Subject: EHG Comments on the Environmental Impact Statement for Oakdale East Industrial Estate (SSD-37486043)

Attachment 1: EHG Comments and recommendations - EIS for Oakdale East Industrial Estate SSD-37486043

The following key issues are raised in relation to Appendix 16 Oakdale East Estate SSD-37486043 BDAR prepared by écologique environmental consulting dated 8 June 2022.

Figure 4.1. Threatened species surveys

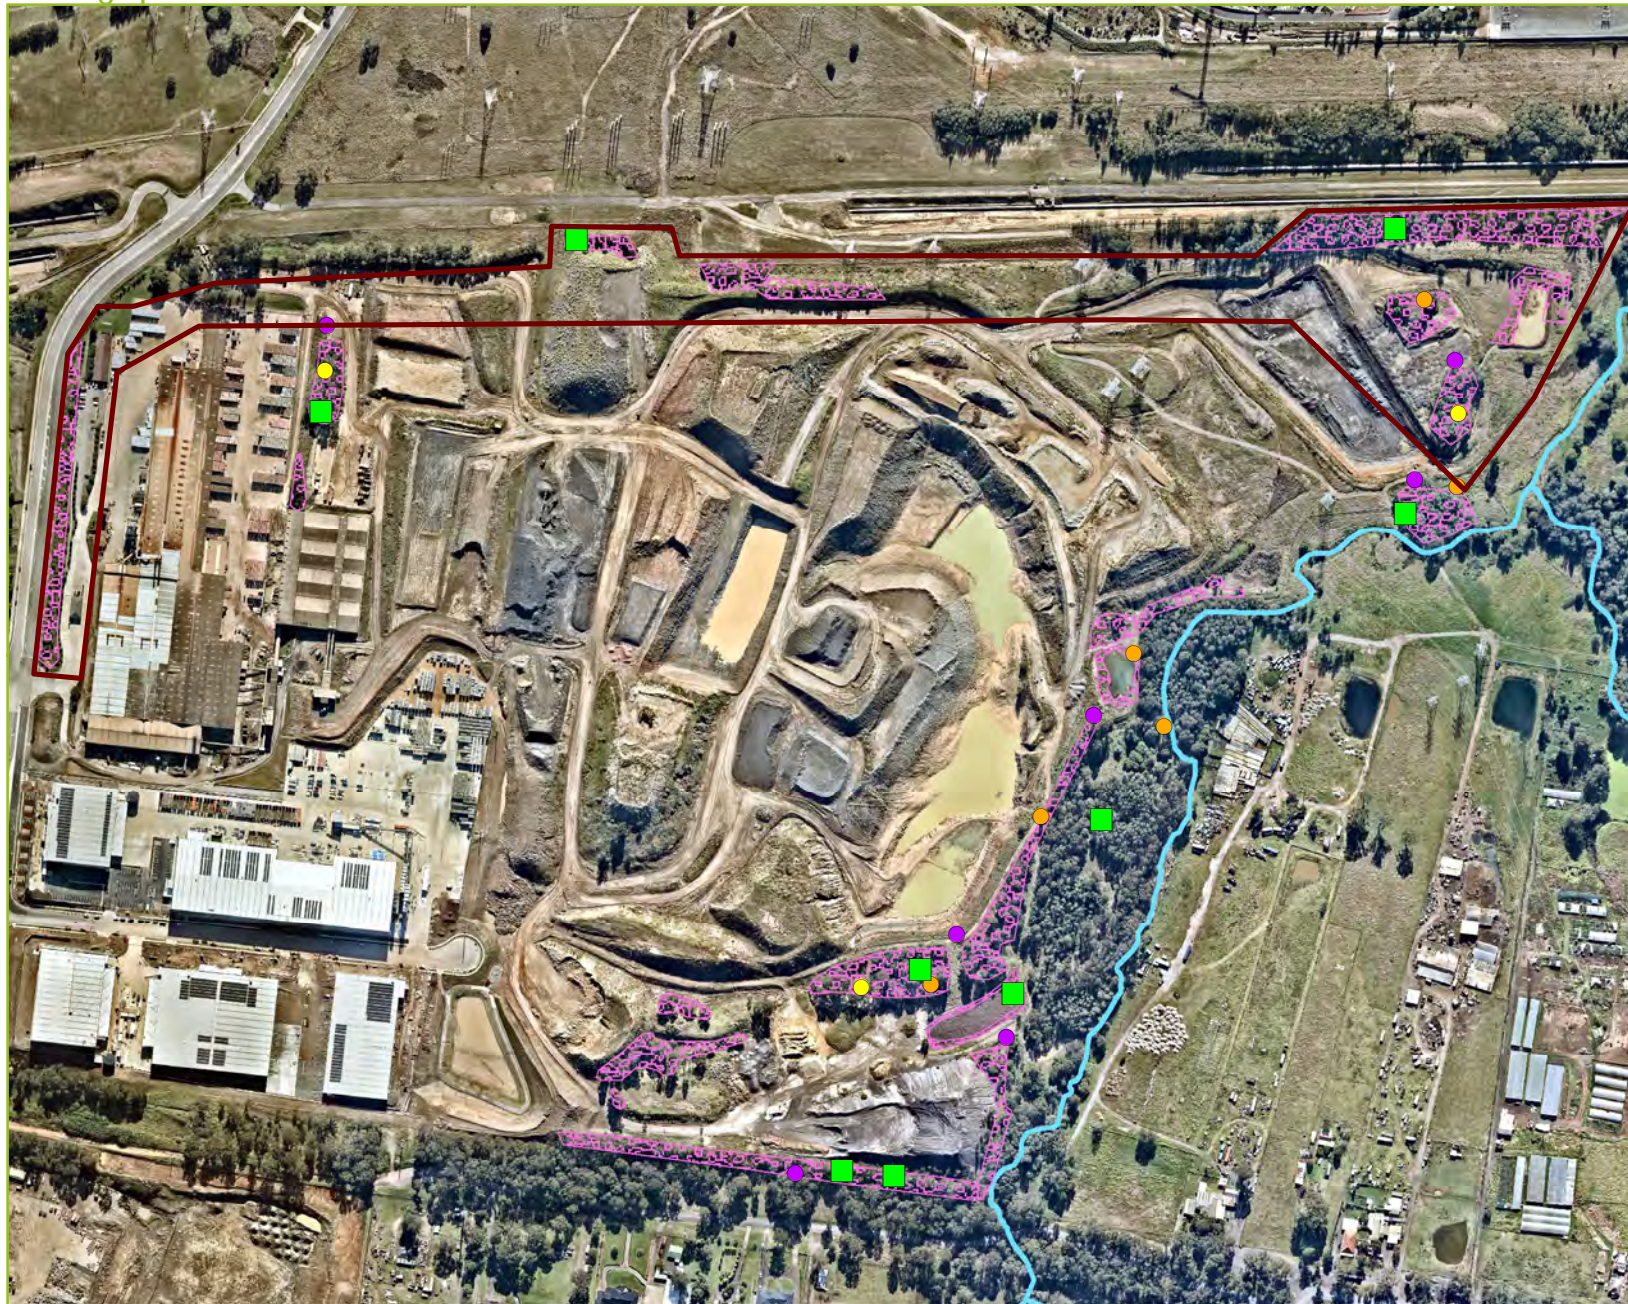
- Section 3.1 states that the location of floristic and site integrity plots and transects are shown in Figure 3-1 but this figure doesn't show plots and transects. It is noted that plot locations are shown on Figure 4-1 but are not overlaid on PCTs, as is required by Appendix K Table 24 of the BAM.
